Application No: EP/124/20/HH
Site Address: Little Dormers 23 Upper Drive East Preston BN16 1QN
Description of works: New bay and porch skirt roof to the front elevation, and roof linked detached double garage.

Thank you for your internet representation made on 12th November 2020 which has been recorded as an objection with the comments as follows:

Floor Plans and Roof Plan -
Proposed

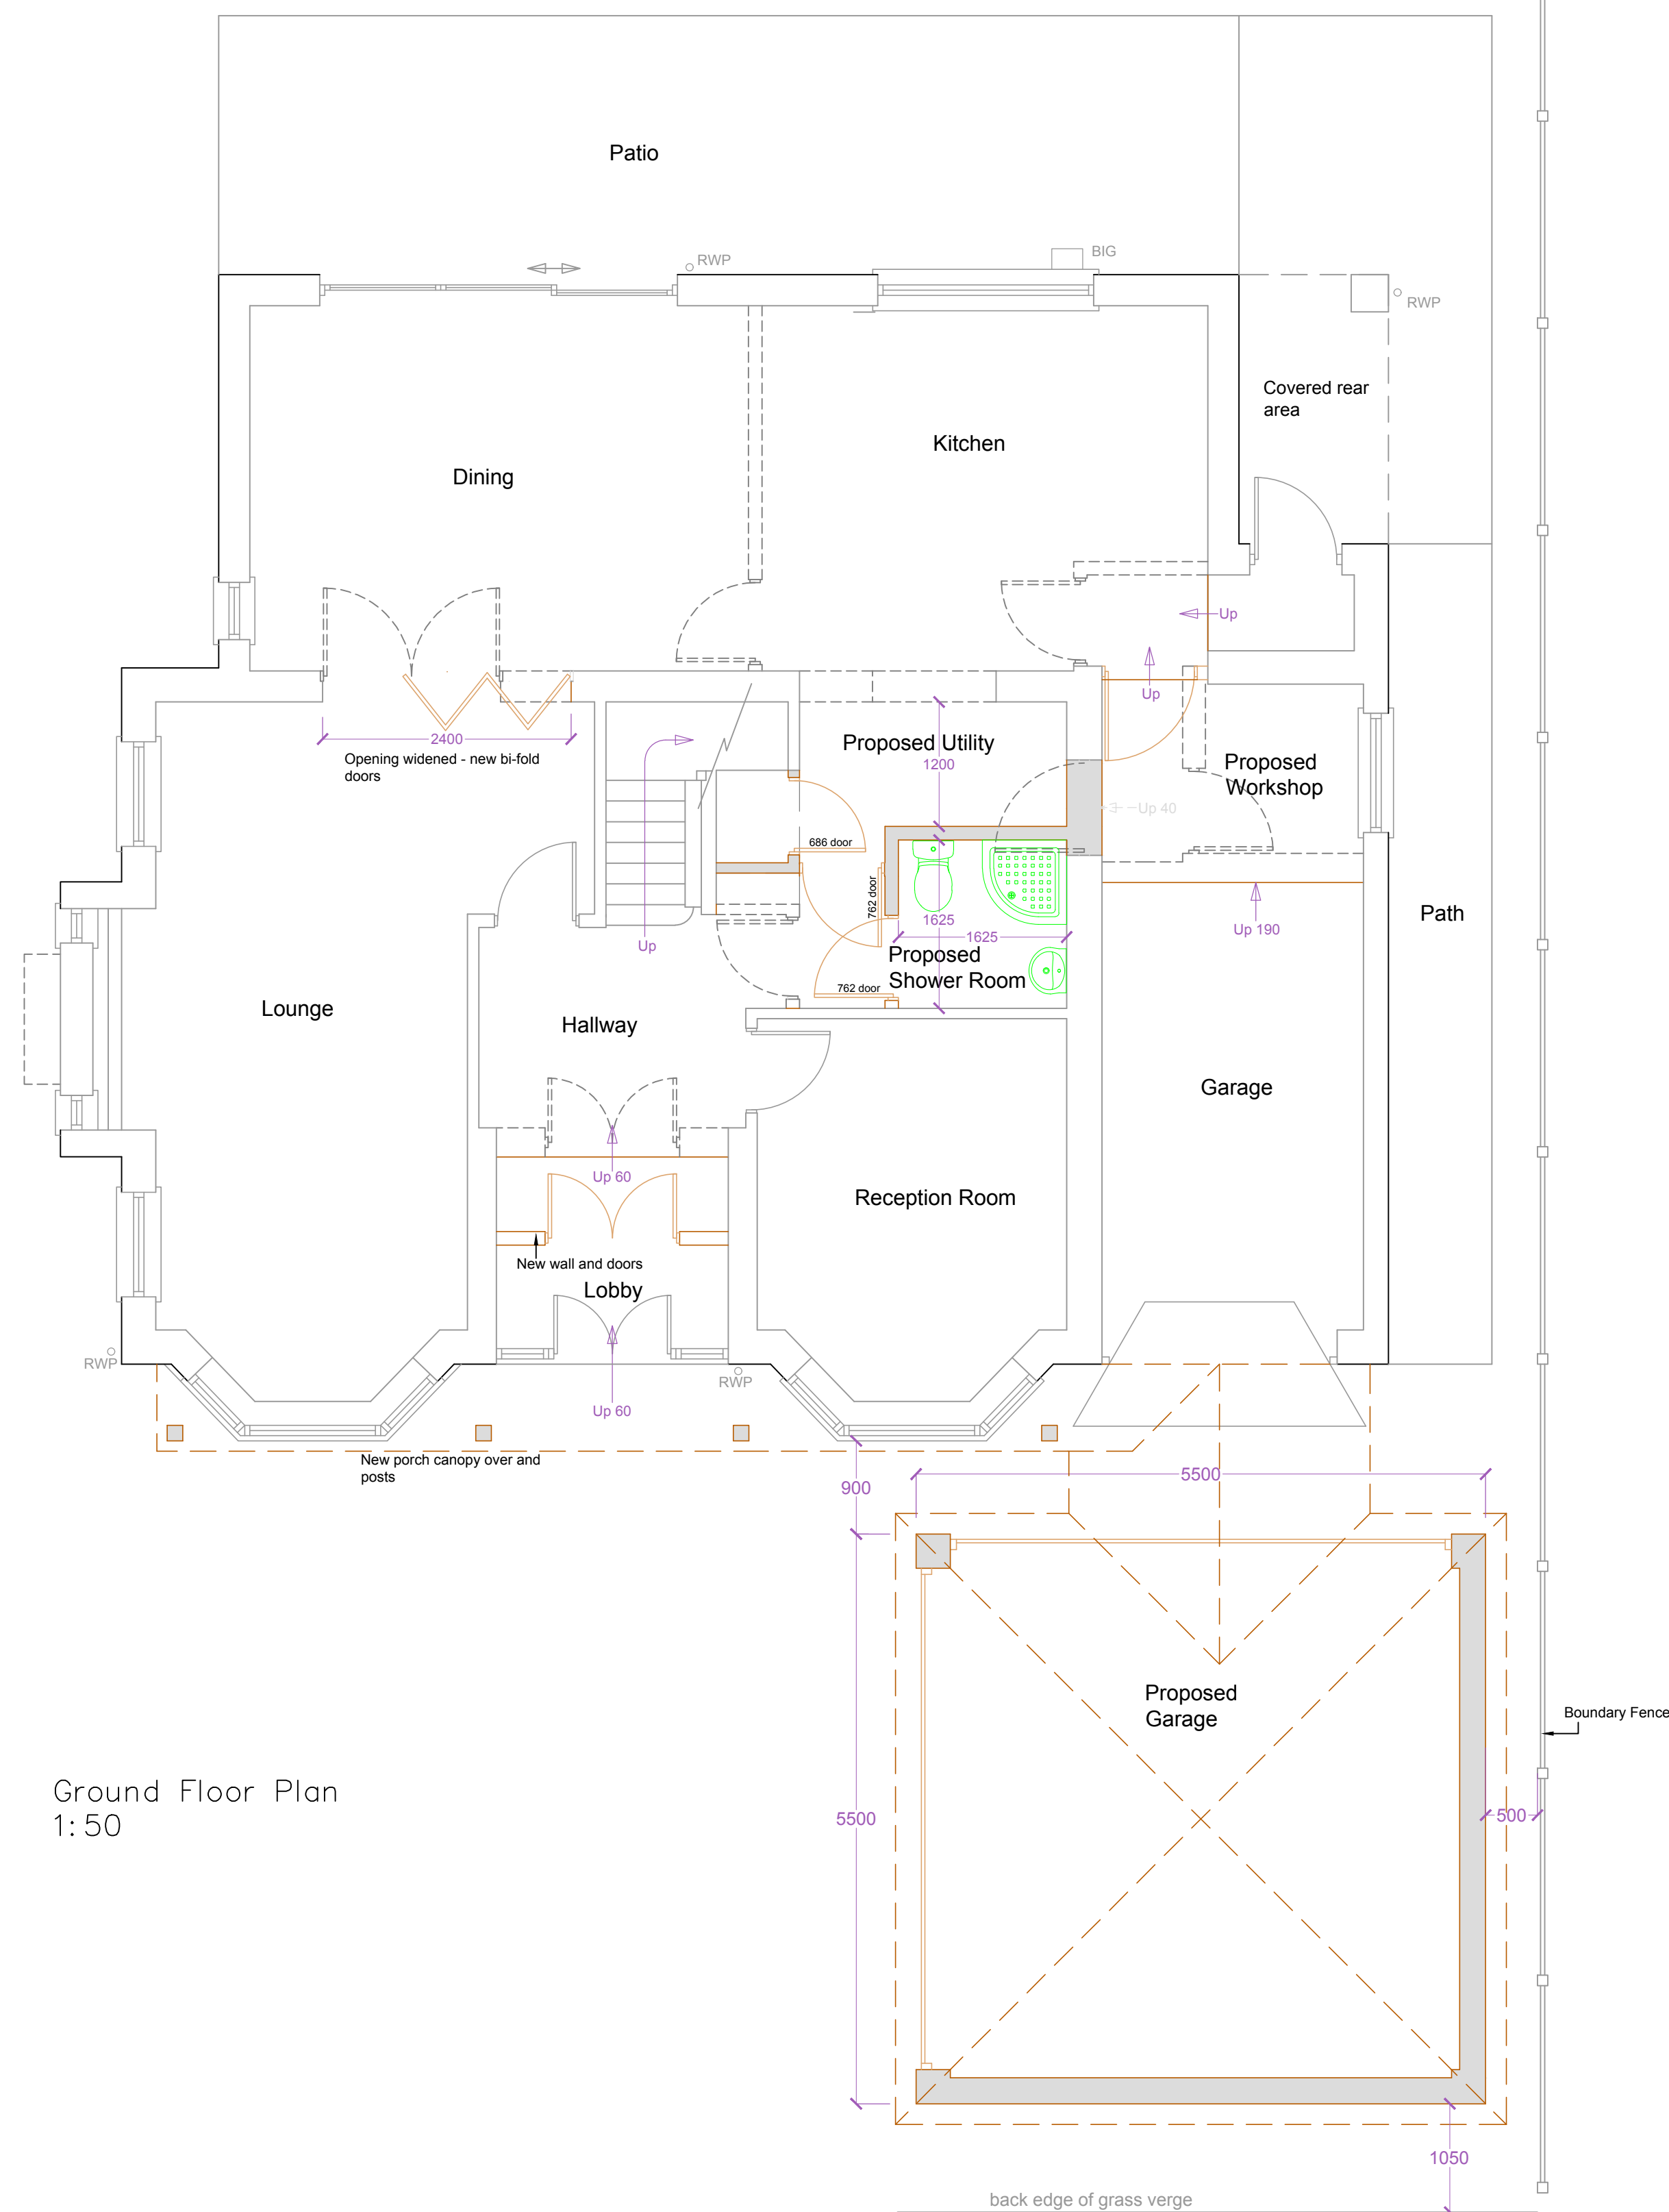
The garage proposal is in complete contravention to the build line of all the other properties within the road; the western elevation of the proposed garage is further forward than the existing Eastern elevation of all other properties in this section of Upper Drive (Excluding 31 Upper Drive, which fronts onto Southview)

The proposed garage is unnecessarily large in both height and width and The proposed garage is too close to the Northern boundary of 25 Upper drive from an aesthetic view point, changing the complete appearance of the road.

The proposed gap between the garage and the boundary of 25 Upper drive is unserviceable from a maintenance perspective

Garage Plans and Elevations -
Proposed

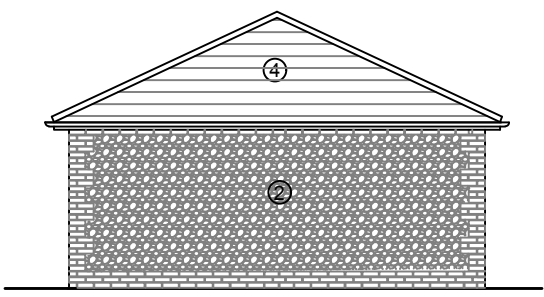
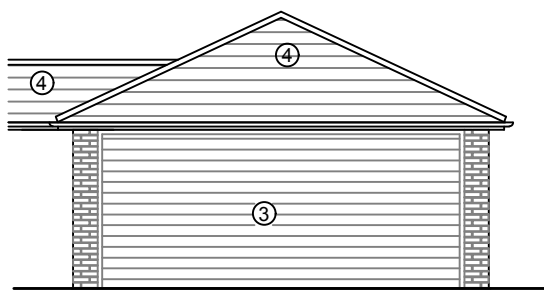
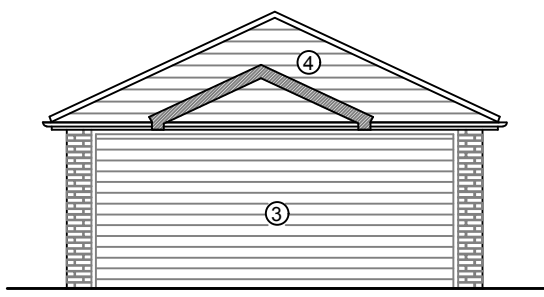
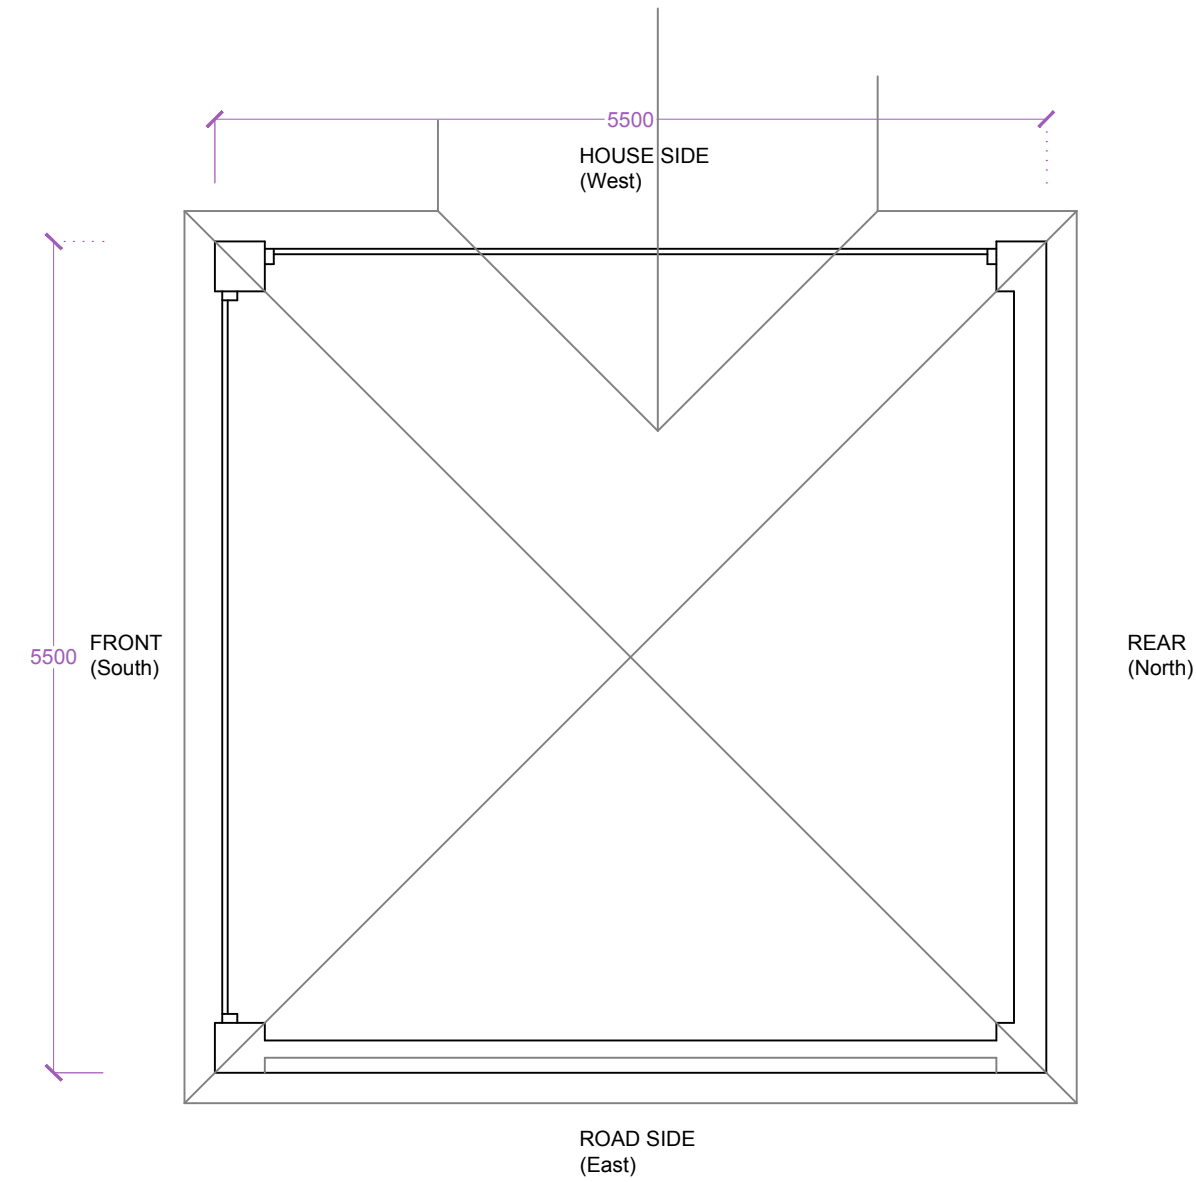
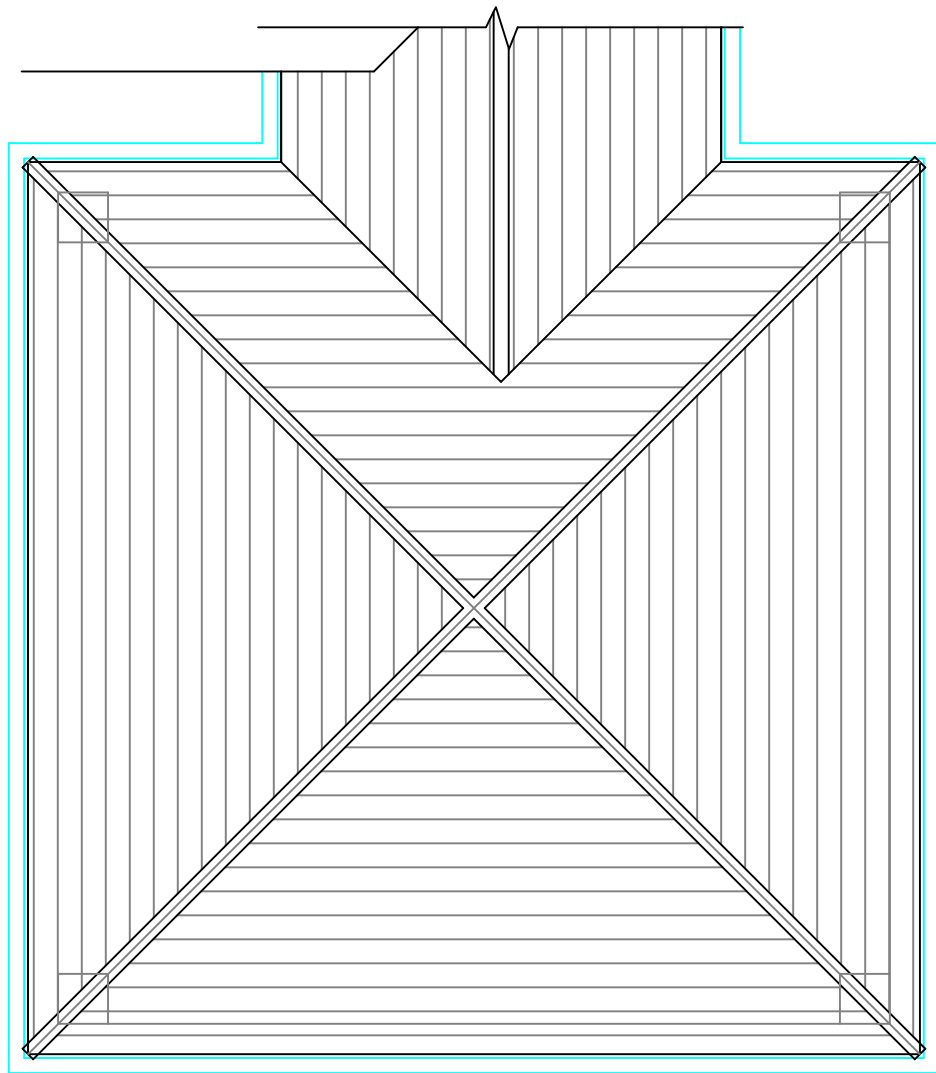
The plot is insufficient to accommodate a detached garage let alone a double structure, hence the original design of the property included an integral single garage

The size of this garage is nearing the size of a separate dwelling. This is unreasonable on the size of this plot in this area.

In addition, I believe these would create a potential danger to those exiting the property at number 25 Upper Drive (both pedestrian and vehicle) as the sight line along Upper Drive to the South will be significantly impaired and the large structure will also block sound from approaching vehicles. There is a danger that injury may result to individuals as a result.
